**Consultation Response from KC,  
Lead Local Flood Authority**

**2023/90768 Land off, Heathfield Lane, Birkenshaw, BD11 2HW**

**Discharge condition 18 (drainage) on previous permission 2019/91534 for erection of 13 dwellings and associated works**

### **Condition 18 – Drainage Details**

TITLE
PRIVATE DRAINAGE LAYOUT

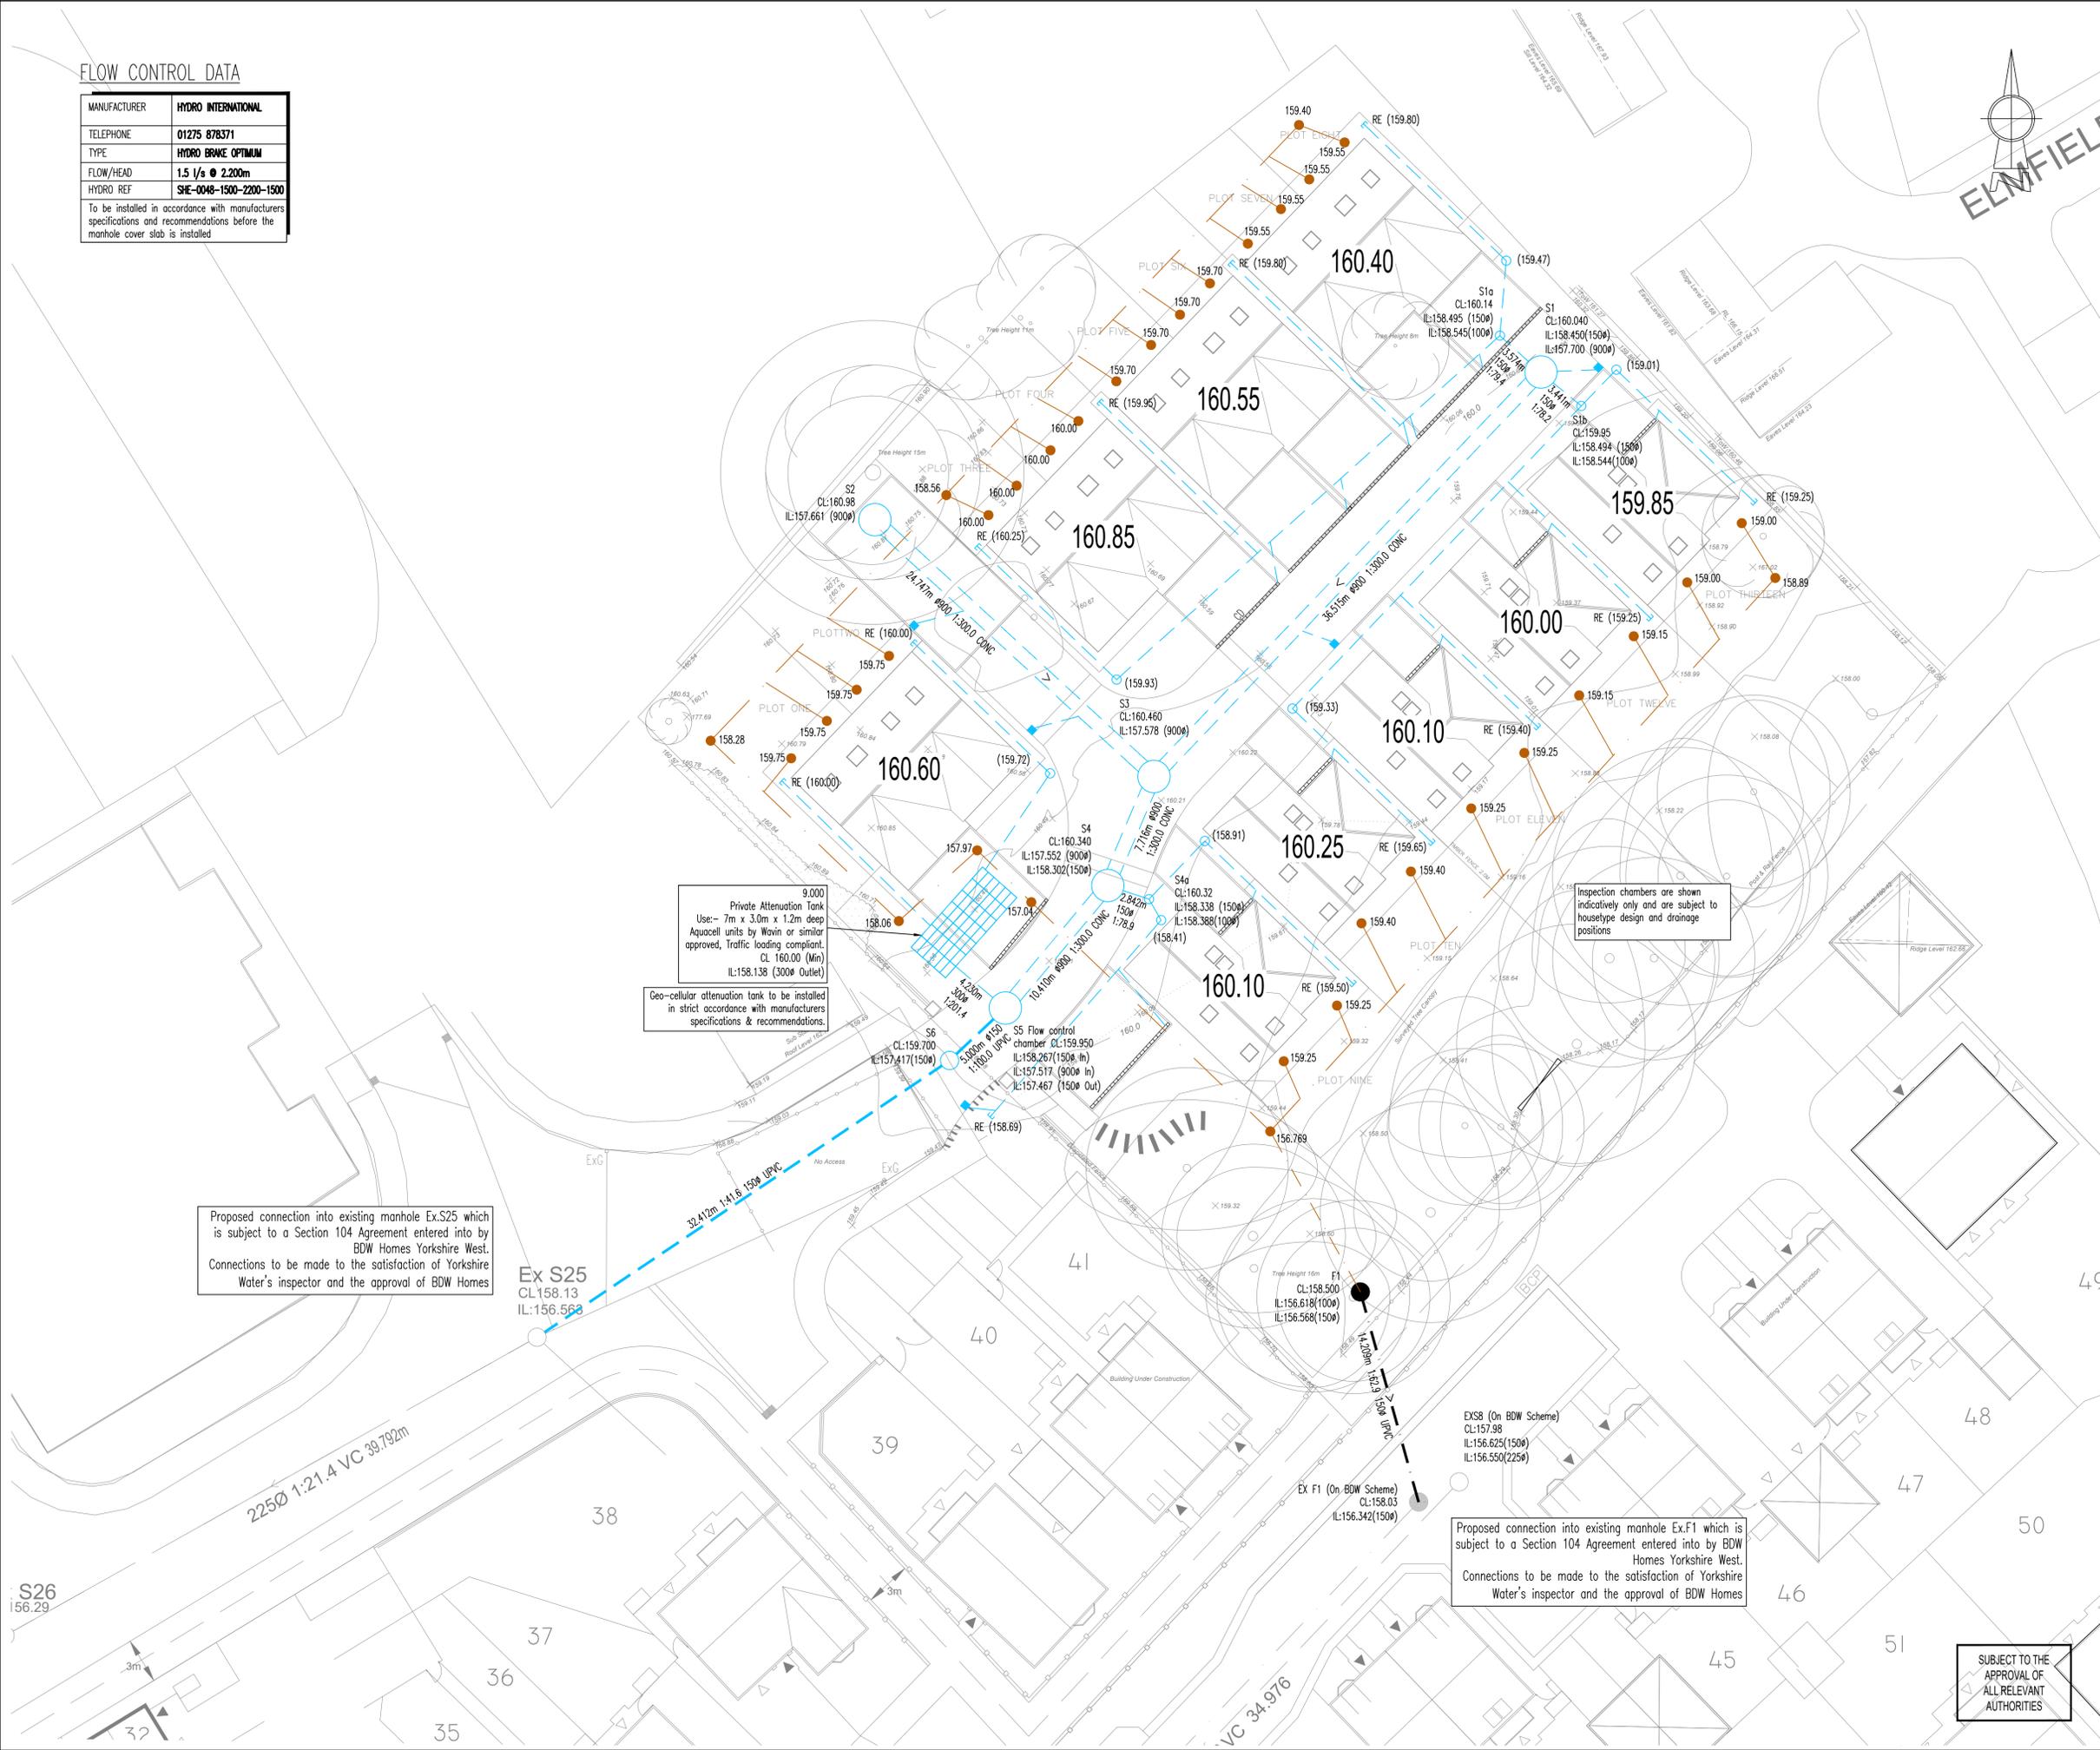
The outfall for surface water is not that promoted in the drawing submitted under 2019/91534

To connect to the Barratts David Wilson site and its ultimate outfall into a highway drain/watercourse in Whitehall Road West and subsequently into the M62 drainage system, it must be demonstrated that the Barratts David Wilson Home site first accepts the connection at 3l/s minimum and 3.5l/s maximum with no flooding as a result on additional volumes entering their previous approved design. In short not to compromise standards achieved on this site.

Kirklees Council also warns the planning officer that this site has an overflow plastic crate system located in a private driveway. This would have been objected to if included in the 2019/91534 application for a housing estate.

TITLE	<b>FLOW CONTROL MANHOLE S5</b>				
PROJECT	<b>BIRKENSHAW HEATHFIELD LANE,</b>				
CLIENT	<b>SLJ WAKEFIELD LTD</b>				
DRAWING STATUS	<b>PRELIMINARY</b>				
Scale	AS SHOWN @ A1	Date	NOV 22	Drawn	BHB
				Chk.	MI
Dwg. No.	2069/03/12			Rev	B

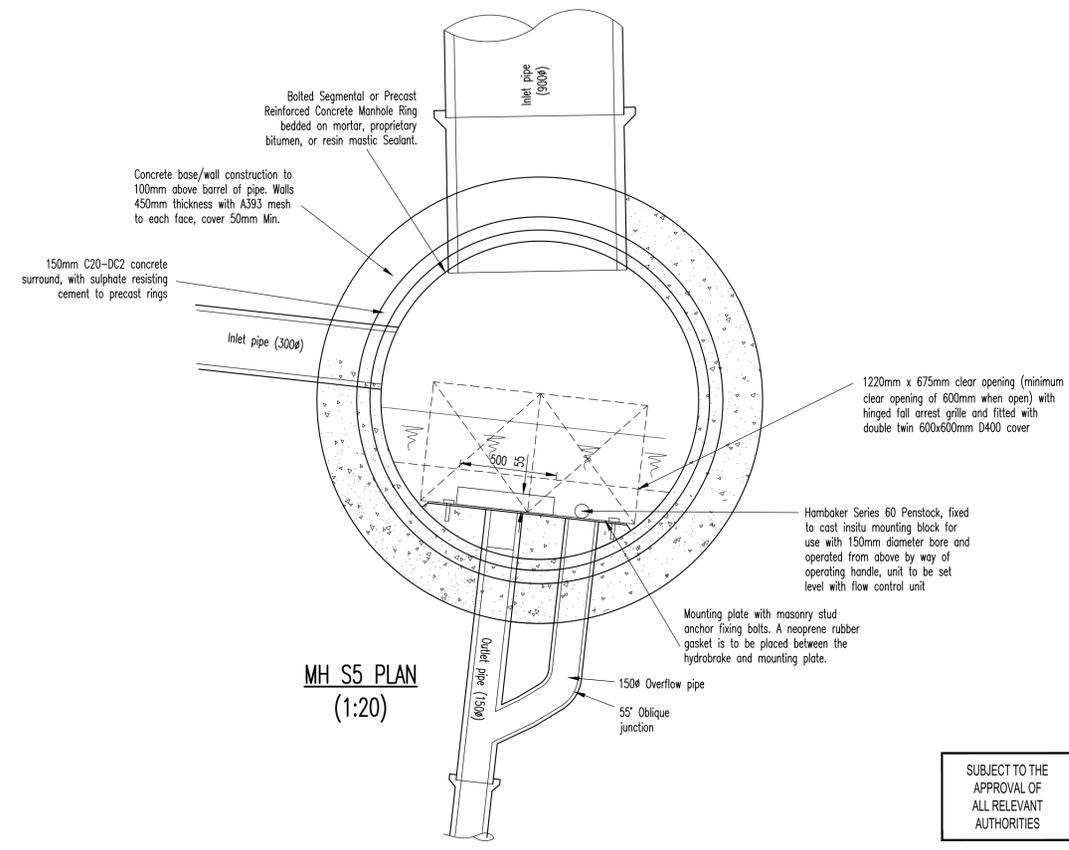
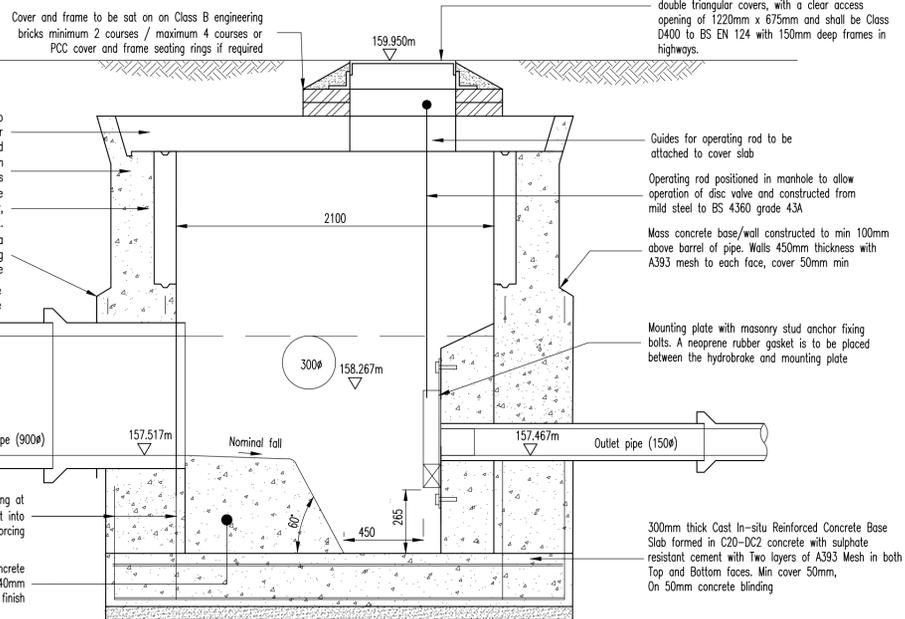
This design including a 1.5l/s discharge restriction and a 45mm orifice falls below minimum standards of 3l/s and a 75mm orifice which are there to adhere to blockage risks.
